**RE: Harnett County Land Use Existing Tank Application # 16-5-39959
Barclays Phase #2 Lot 18**

Based on the criteria set out in Title 15A, Subchapter 18A, of the North Carolina Administrative Code, Rules .1950, the evaluation indicated that the site is **UNSUITABLE** for the addition requested. Therefore, your request for an existing tank is **DENIED**. The site is denied based on the following:

Garage Placement  
91 Woodstone Pl.

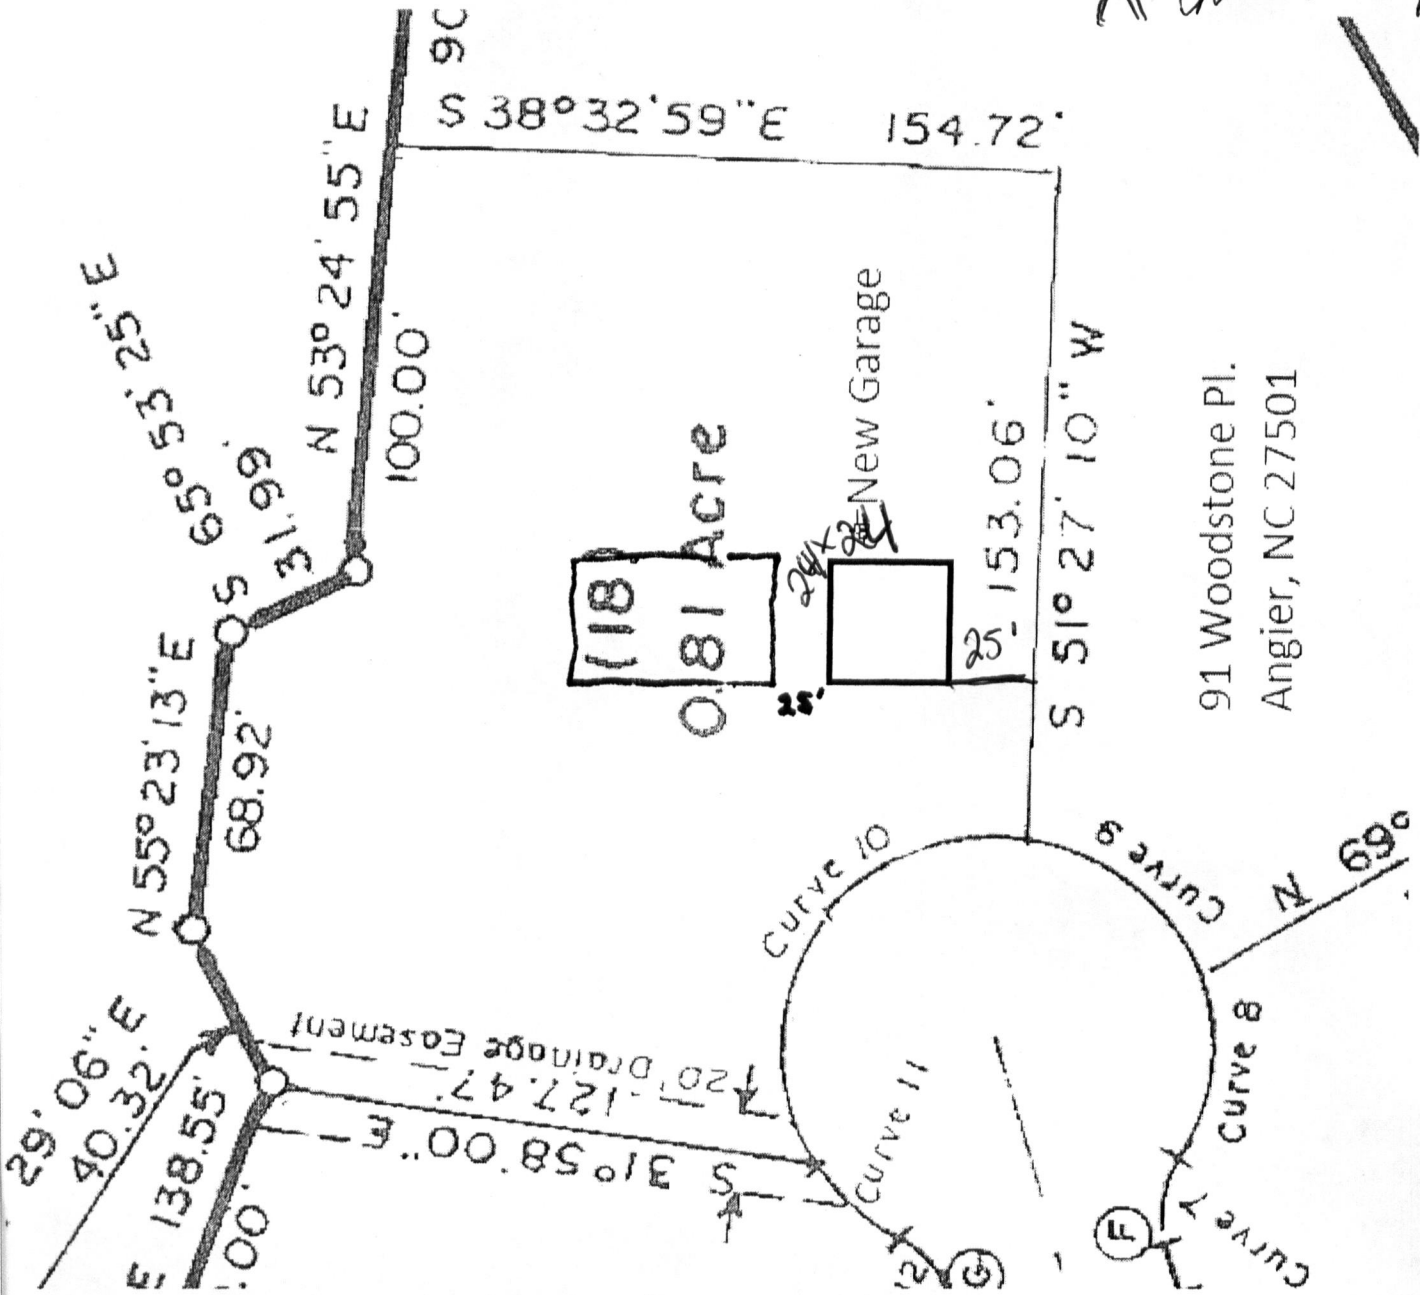
- 15A NCAC 18A.1950a {16} - Any swimming pool must be 15' from any part of septic system.
- 15A NCAC 18.1945{b} - Each lot shall have original septic system plus repair area.
- 15A NCAC 18A.1950 {10} - Any building to be 5' from septic tank and/or from drain line.
- 15A NCAC 18A.1950{c} - Nitrification fields and repair areas shall not be located under paved areas or areas subject to vehicular traffic.
- Incorrect lid was uncovered
